Department of Environmental Health

Re: Status of Repair Application EH2102-0009

# Harnett County Department of Public Health Site Sketch

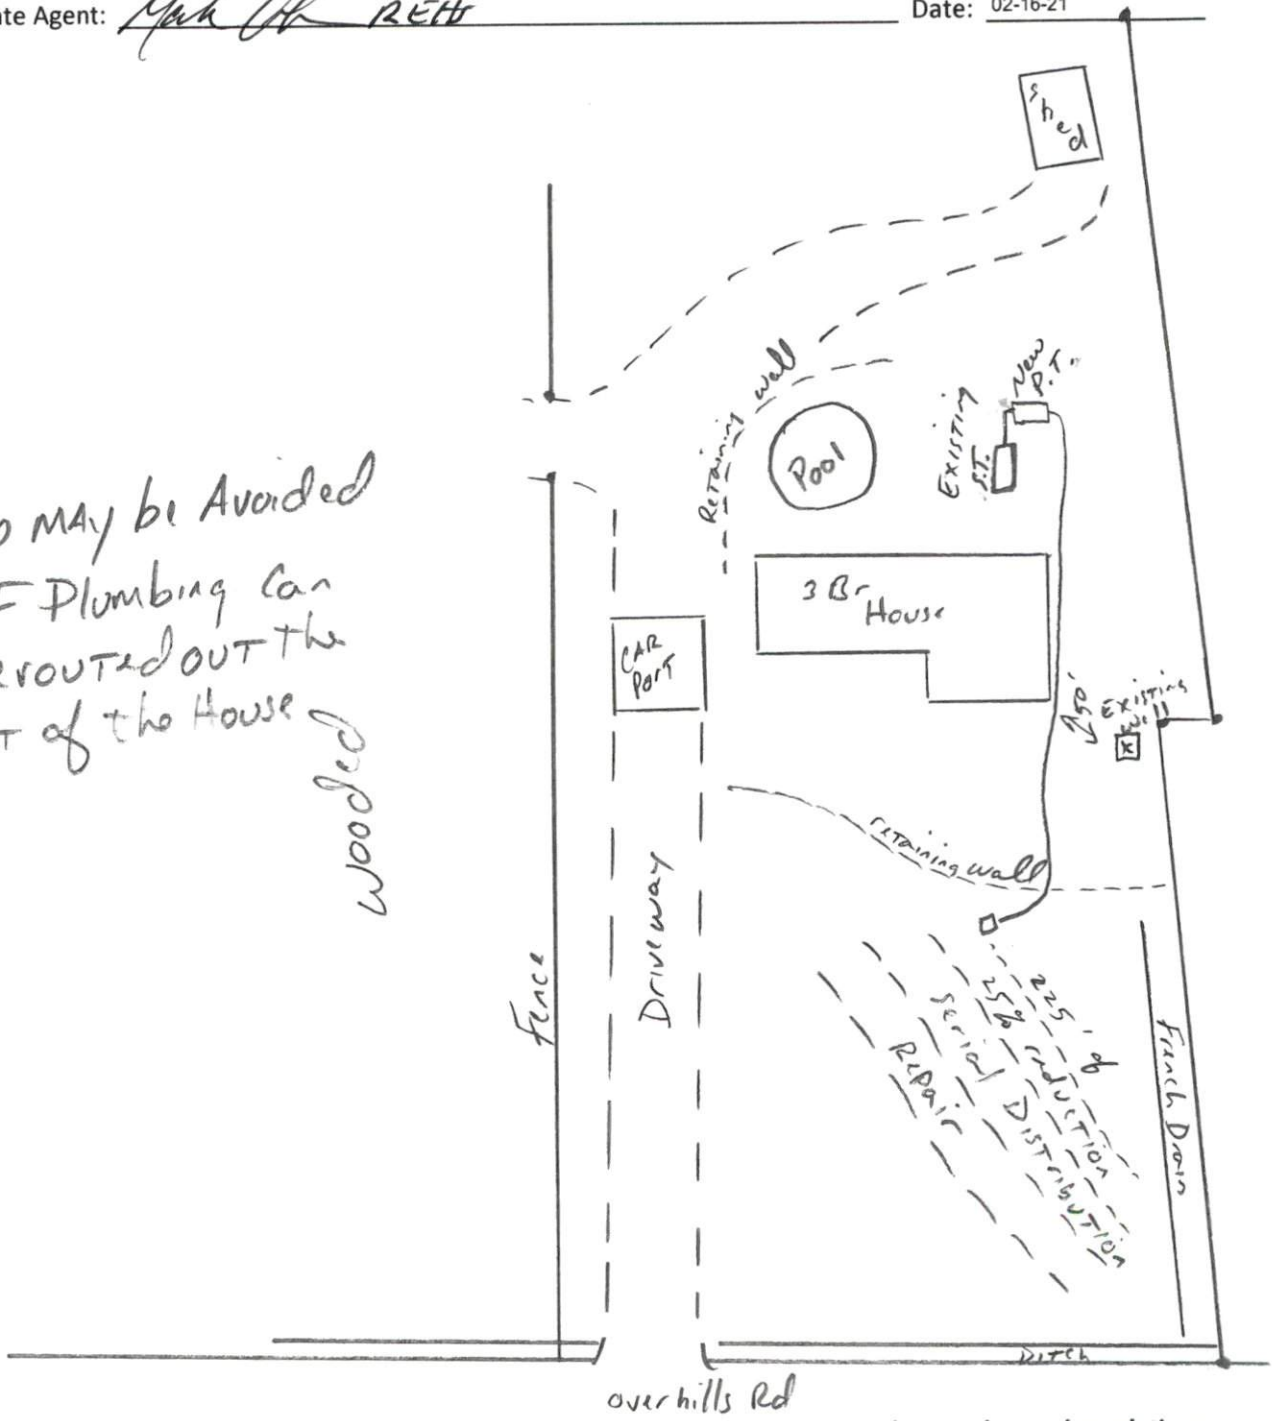
- 1. Use pink flags or stakes to mark property lines and irons that are set by surveyor need to be visible.
- 2. Use orange flags to mark house box.
- 3. Directions not clear to property (\$25.00 fee incurred)
- 4. Property needs cleared
- 5. Driveway not shown on site plan (Revision Required)
- 6. Backhoe pits required
- 7. Other-
